**Andrew Beattie - Berry Riding club**

**The Issues Associated with the Design of the Proposed Relocation of the Berry Equestrian Centre**

This submission concerns the impact of the proposed Foxground and Berry Bypass on the Berry Equestrian Centre which is located in North Street Berry.

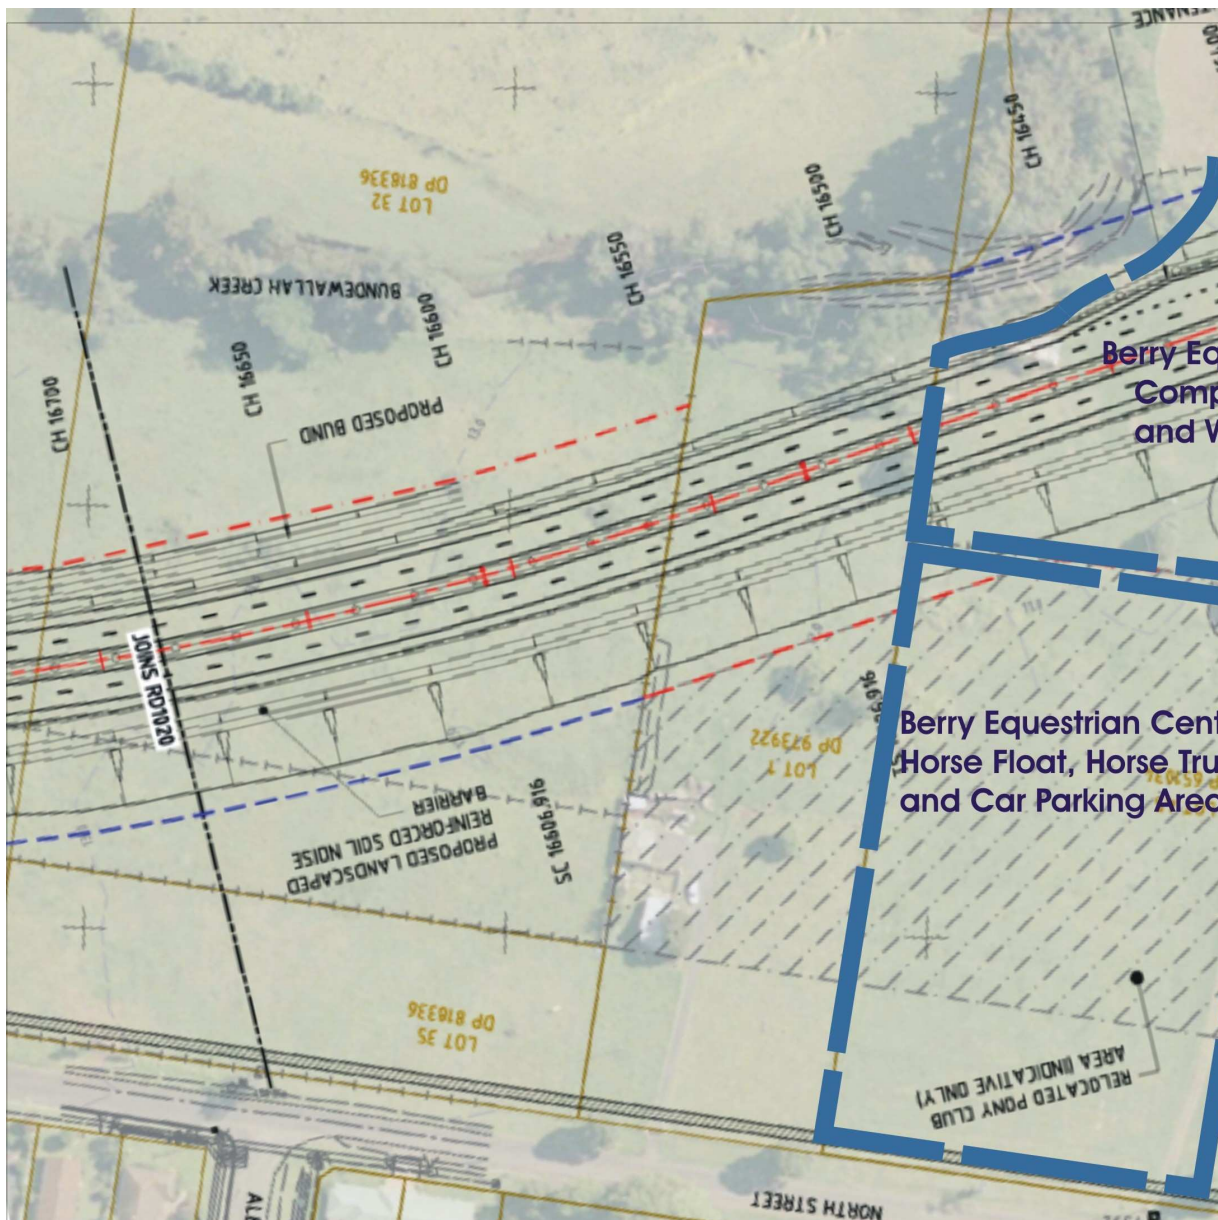
1. The competition grounds are required to be rectangular /square in shape of a minimum size of 140 metres x 140 metres with a level, well drained, good riding surface in order to cater for at least 4 dressage arenas or 2 showjumping arenas.

2. The parking area is required to be of a minimum area equivalent to 90 metres x 160 metres and allow for easy entry, maneuverability, parking and exit of horse floats and trucks. Each parking space is equivalent to an absolute minimum of 4 normal vehicle spaces due to the need for unloading/loading and tie up areas for horses.

3. There is concern for the safety of horses, riders and the general public due to the near location of the proposed riding area to the 4 lane expressway, the skateway, the public cycleway/walkway and North Street. There will be anticipated significantly increased noise and visibility of cars and trucks travelling at 100km/hour on the expressway with horses competing nearby, often with young, very inexperienced riders.

4. Access to the grounds is likely to be across a public shared cycleway/pathway. The safety of children on skateboards, bicycles etc are at risk as horse trucks and floats cross the pathway. Horse floats and trucks also require an indented driveway of at least 15 metres to allow vehicles to park off the roadway whilst gates to the grounds are opened.
